Recommendation Report for Planning Permission for Works or Extension to a Dwelling

REF NO: BR/157/21/HH

LOCATION: 18A Devonshire Road
Bognor Regis
PO21 2SY

PROPOSAL: Conversion of roofspace to habitable use to include 2 x rooflights and alterations to fenestration

Proposed South Elevation Scale 1:50

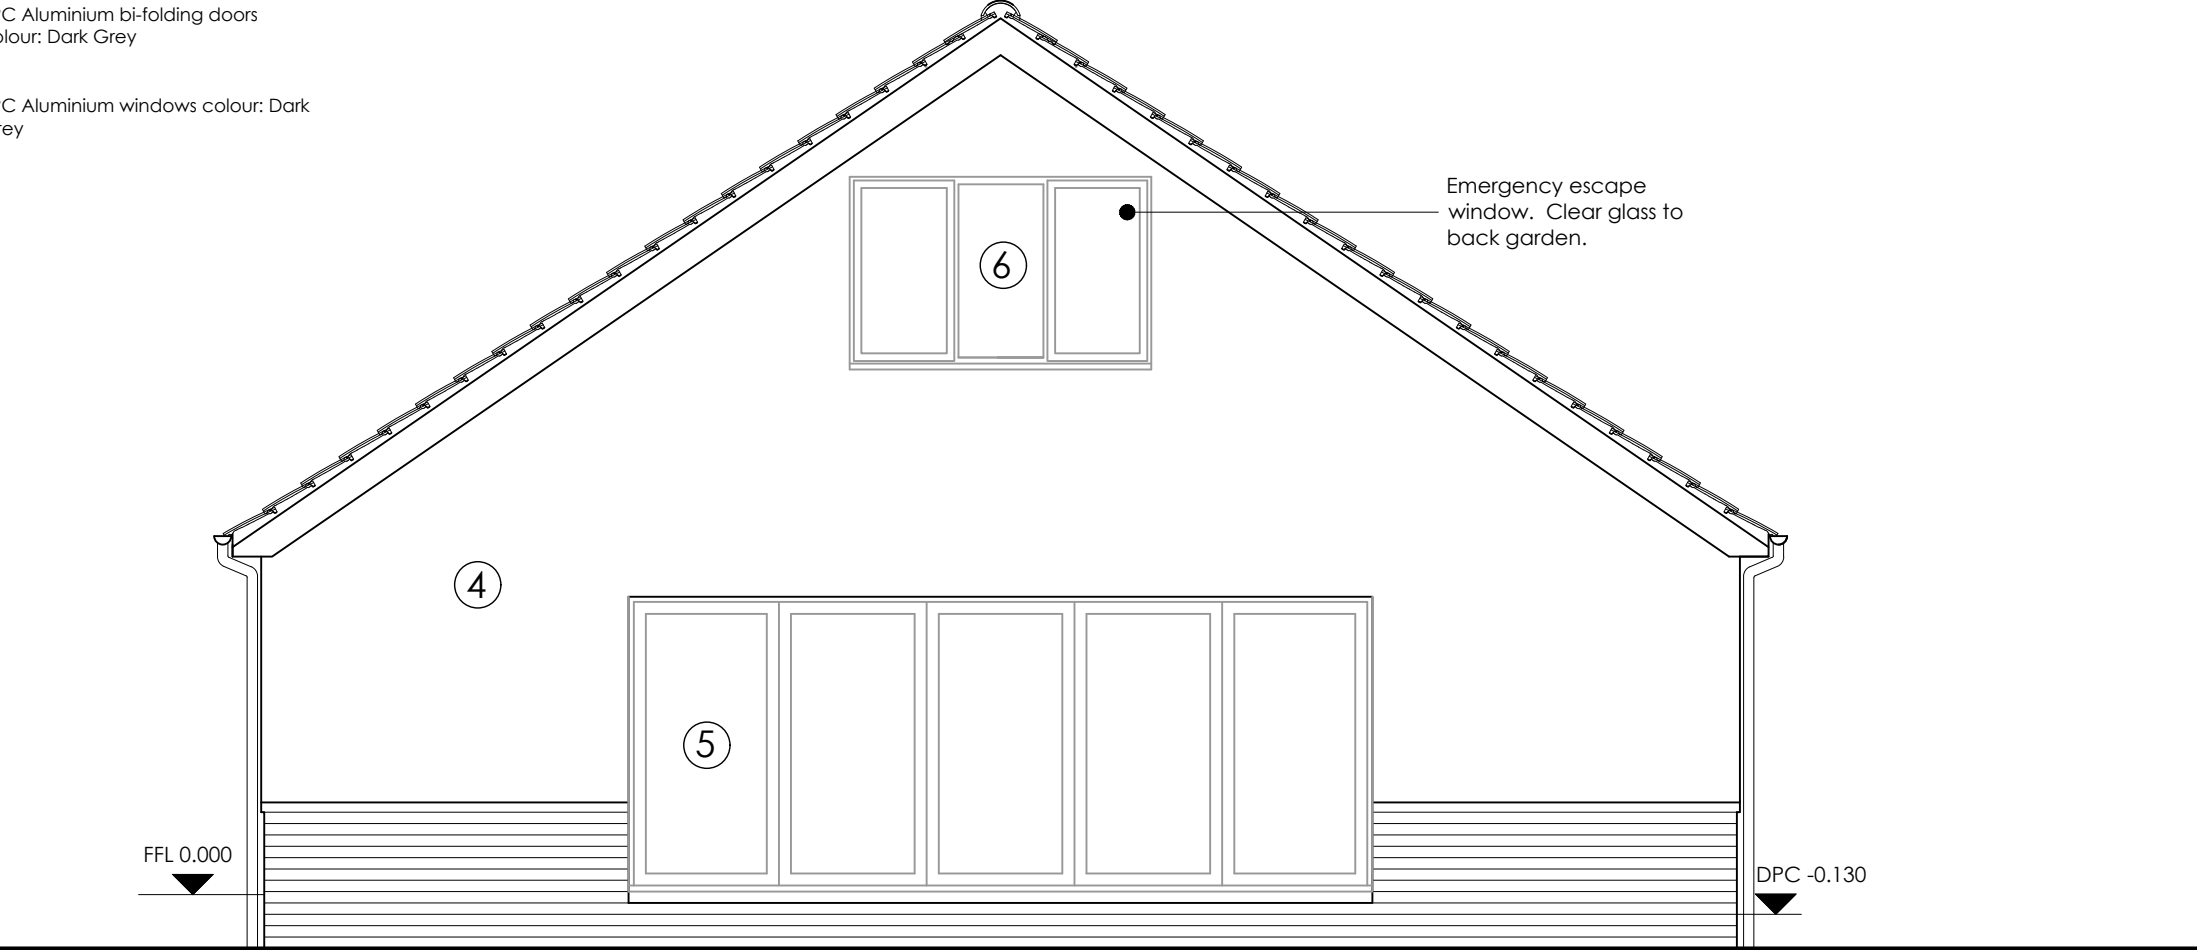
The proposals also include alterations to fenestration of property including removing bay windows to rear (south) elevation of property, making the rear elevation flush at eaves and installation of bi-fold doors to rear. Due to the siting of alterations at rear (south) of property and location of property set back from Devonshire Road by private driveway there is no adverse harm to street scene or character of area so complies with policy D DM1 of the Arun Local Plan.

The proposals also include a new triple window to rear (south) first floor elevation to act as an emergency fire escape.

Due to the proposed alterations to fenestration to rear (south) elevation and removal of existing bay windows there will be replacement bi-fold doors to rear. Whilst there is increased risk to overlooking to neighbouring properties to south, the location of neighbouring properties gardens to south set back and being at single storey and location of boundary fence to south there is no adverse harm to overlooking to south so is acceptable.

Due to new triple window to rear (south) first floor elevation there is increased risk to overlooking to neighbouring properties to rear however due to neighbouring properties gardens to south set back there is no adverse harm to overlooking to neighbouring properties to south so is acceptable.

Proposed West Elevation Scale 1:50

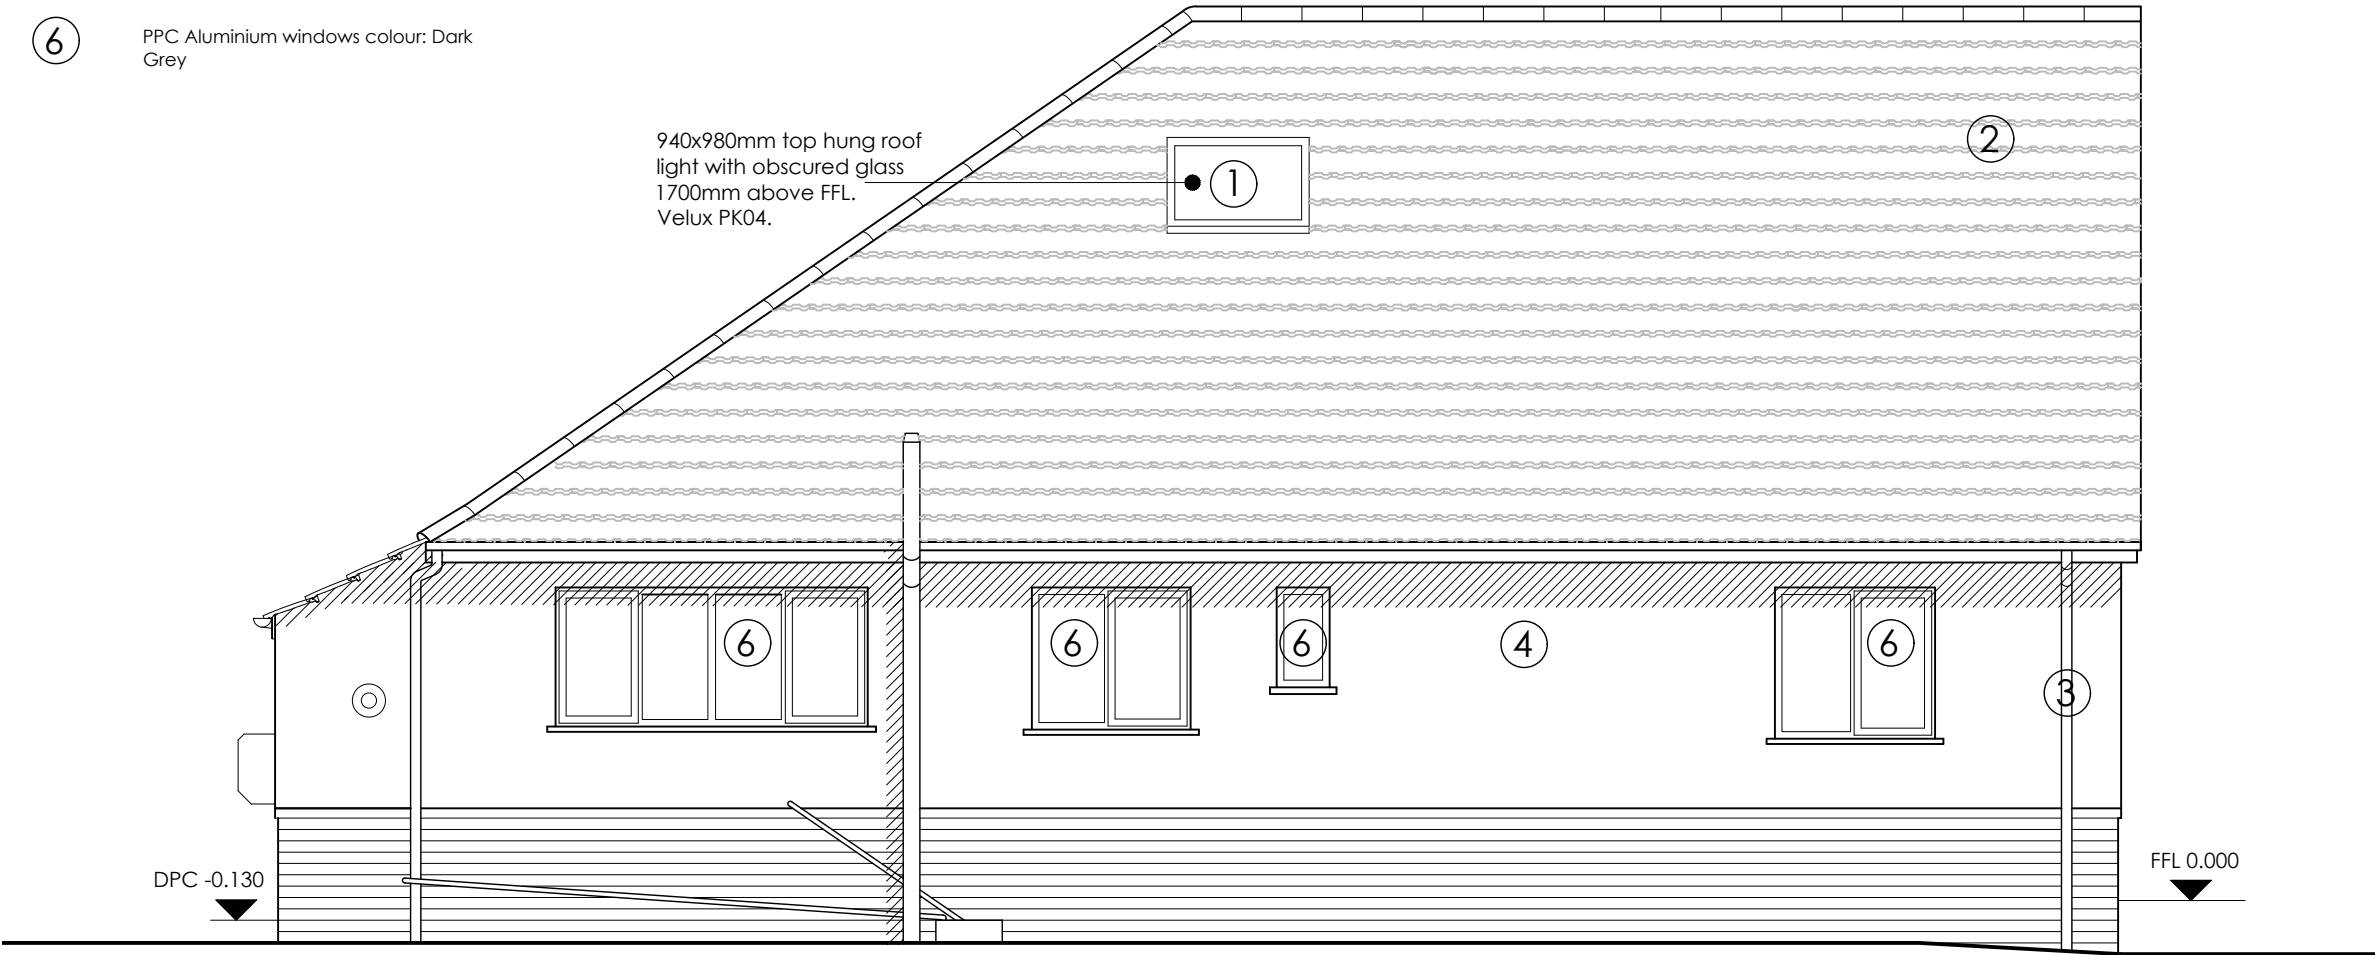
Due to a new rooflight in west elevation of roof, there is increased risk to overlooking to neighbouring properties to west however due to properties to west set back by gardens and glazing of roof light there is no adverse impact overlooking effects to neighbouring properties to west so complies.
